Recommendation Report for Planning Permission for Works or Extension to a Dwelling

REF NO: AW/275/18/HH

LOCATION: 229 Manor Way
Aldwick
PO21 4HT

PROPOSAL: First floor side extension, loft conversion with rear dormer, rear canopy, and extension to detached garage. This application affects the character and appearance of Aldwick Bay Conservation Area

Scale: 1:100	Drawn: V. BOTEZAT	Checked: R. Stefonski	Approved:	Date: 26.07.2018
Job No: 1352	Drawing No: 103	Revision:

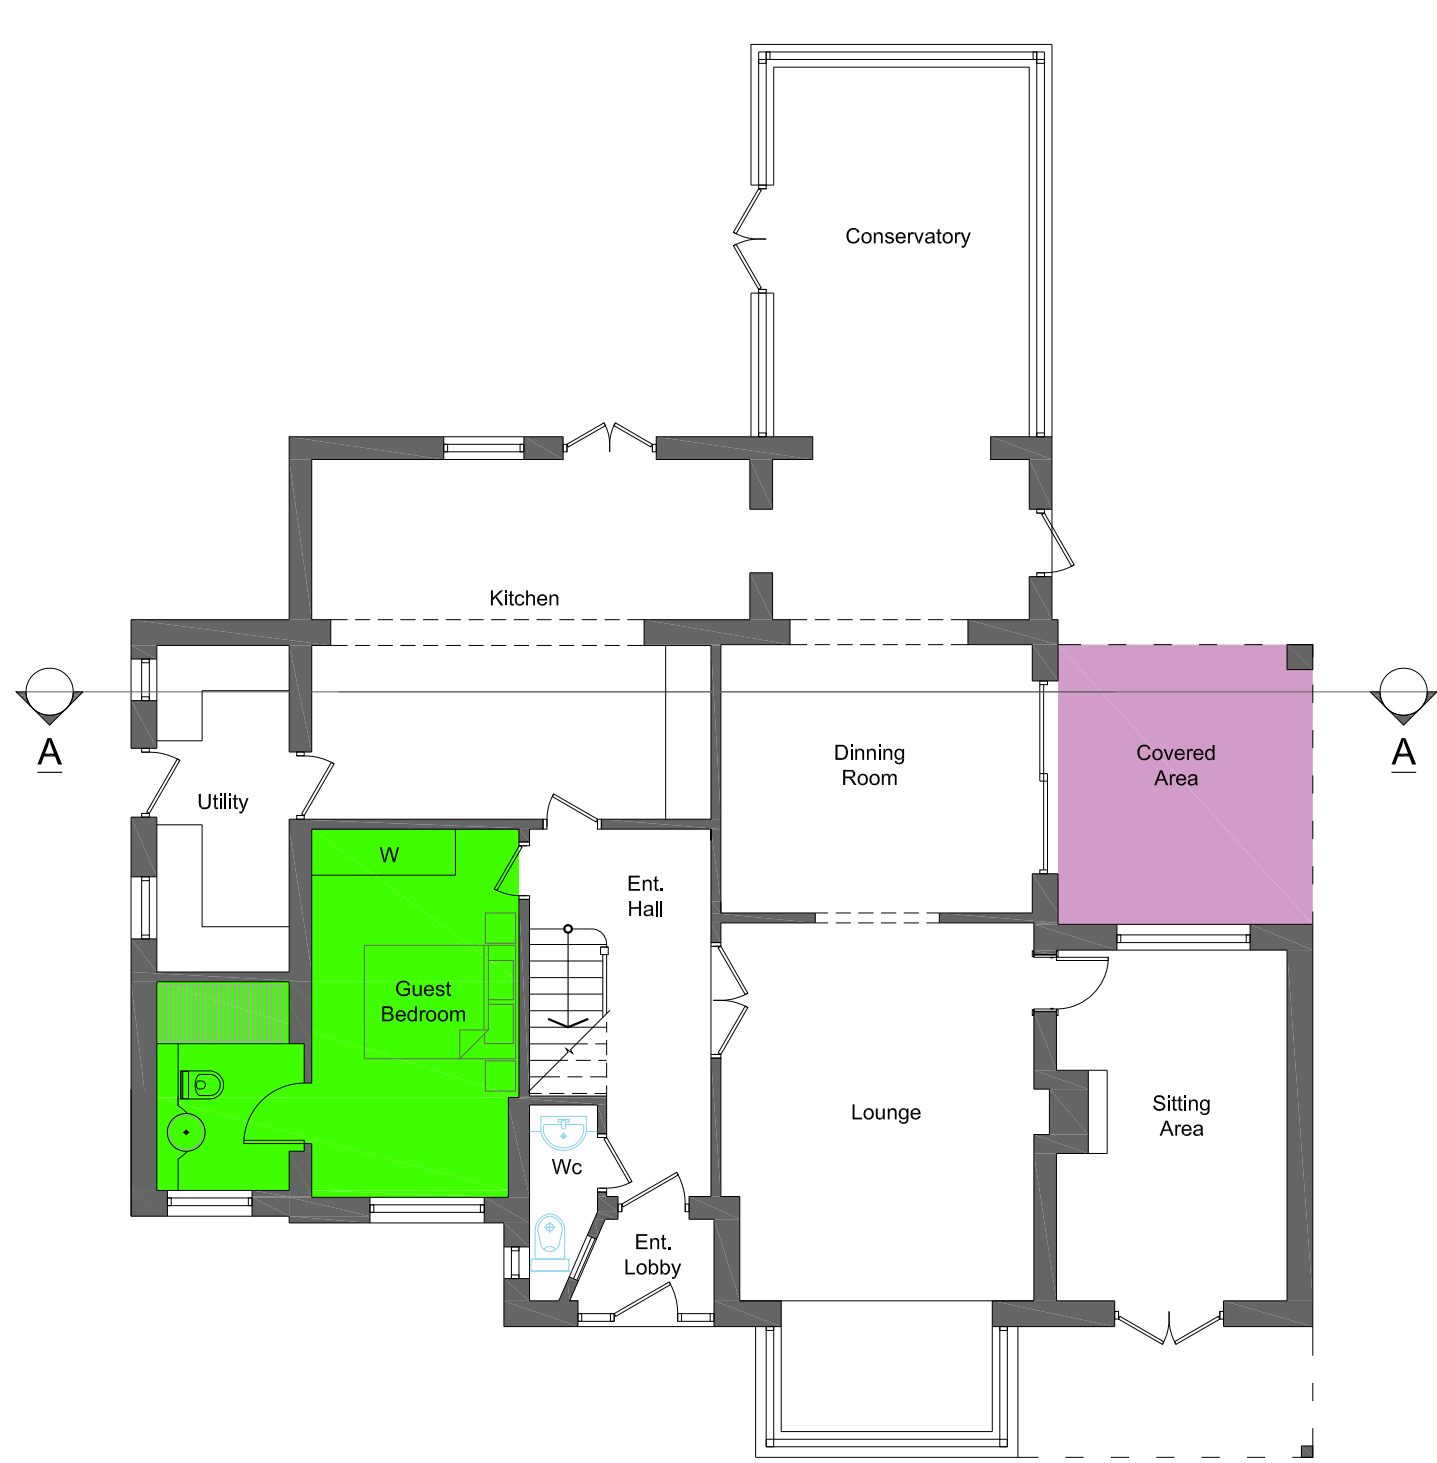
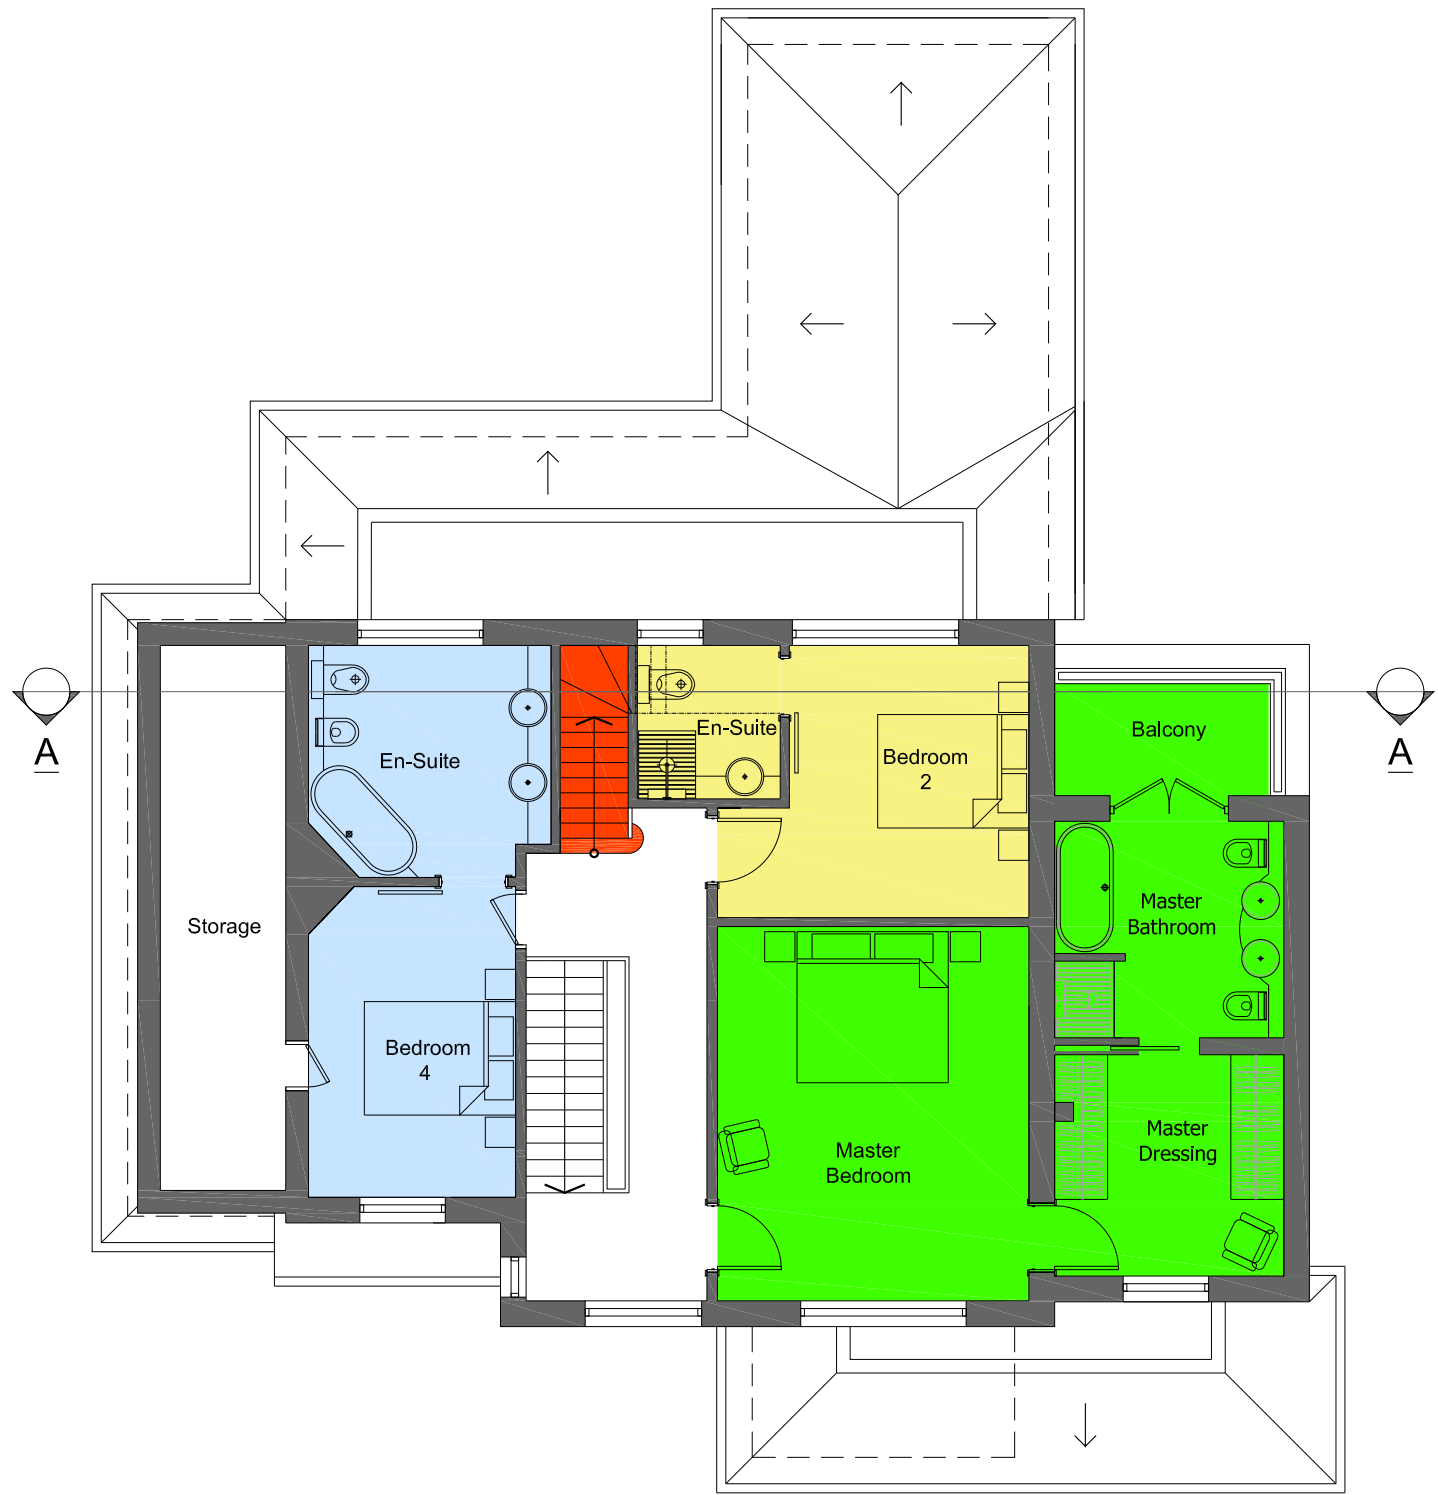
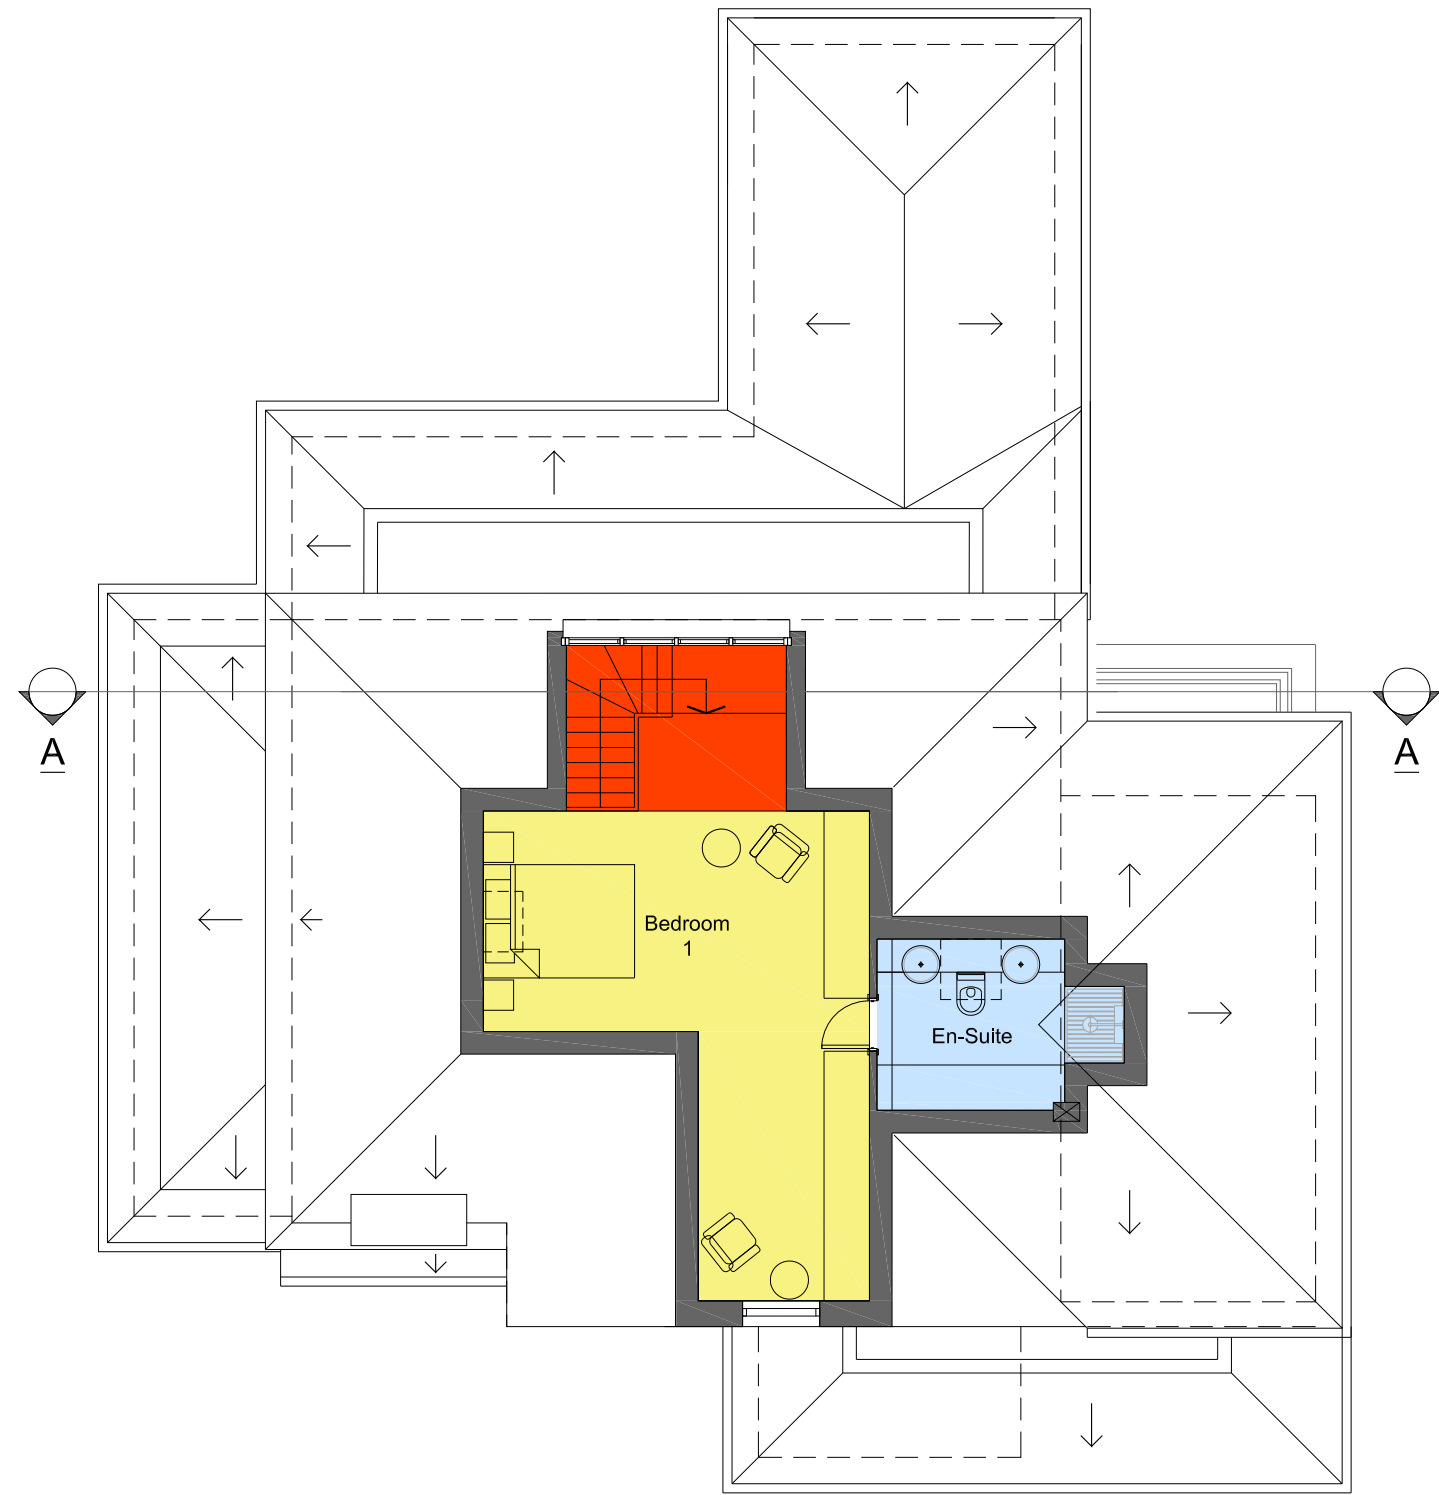
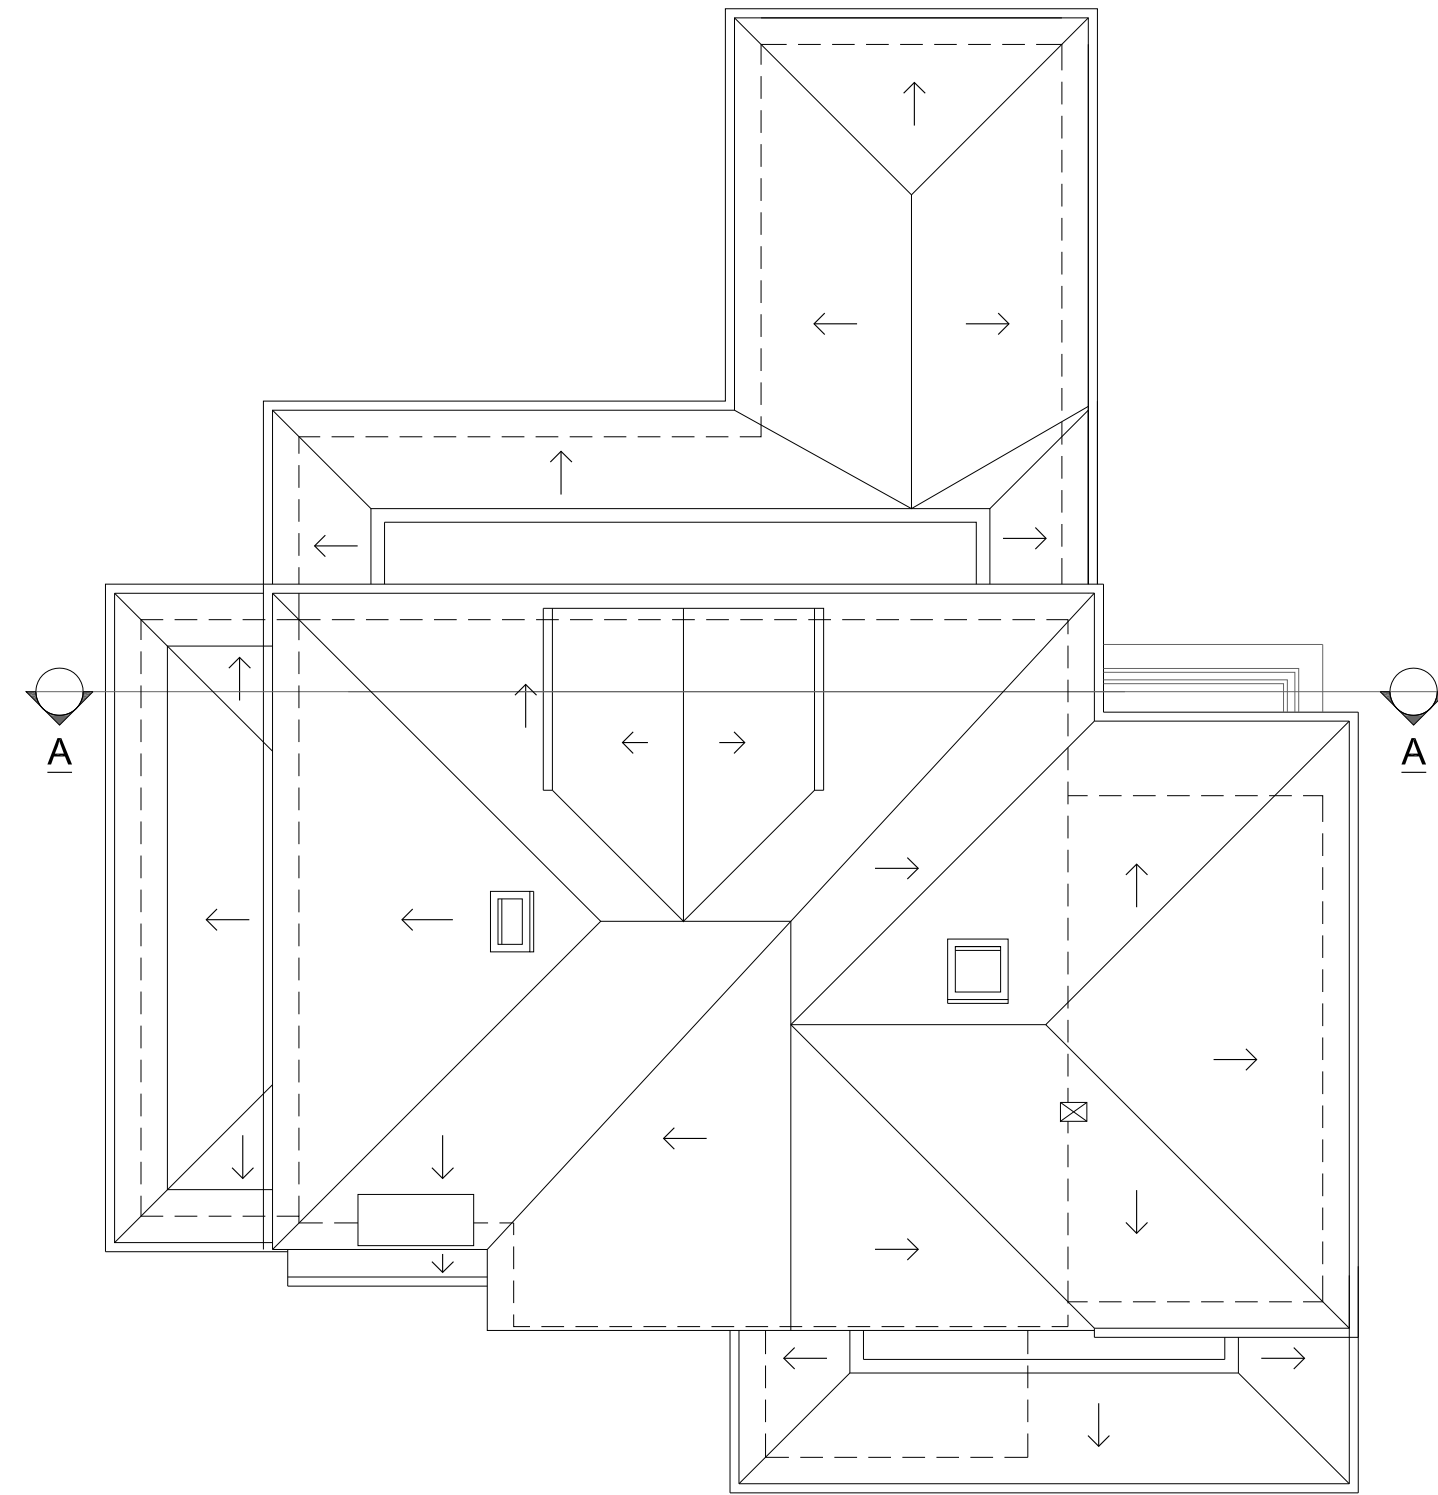
The proposed first floor side extension will be located to the south eastern elevation. The extension will increase its depth 3.7m to the rear of the dwelling although will not extend beyond the rear elevation of the property. The extension will provide a first floor balcony with a covered area below and will have a hipped roof to match the ridge height of the host dwelling. The proposed balcony will have screening to restrict any potential overlooking upon the property to the south east. Due to the shape of the boundary there will be a separation distance of 1.1m to the south east and due to its siting and the boundary treatment in place is not considered to give rise to significant overshadowing or overbearing upon the neighbours at this elevation.

The proposal also involves a conversion of the loft space to create an additional bedroom and bathroom and as a result a rear dormer will be constructed. It is relatively large with a depth of 4m extending from the ridge line of the host dwelling. It will have a height of 3m and a width of 3.4m with a gable roof. However, the window serves a staircase/landing area and therefore any overlooking is not considered to be significant. Also due to the siting of the dwelling to the north west which is set around 13m behind that of the host dwelling, it is not likely to give rise to any adverse overlooking at this elevation or to the rear where there is 30m separation to the boundary.

- 4 The balcony screening shall be constructed as shown on the approved drawing 103 to the

north east and south east elevation to a height of 1.7m and retained in its entirety in perpetuity. The balcony shall also not be used until the balcony guarding is completed.
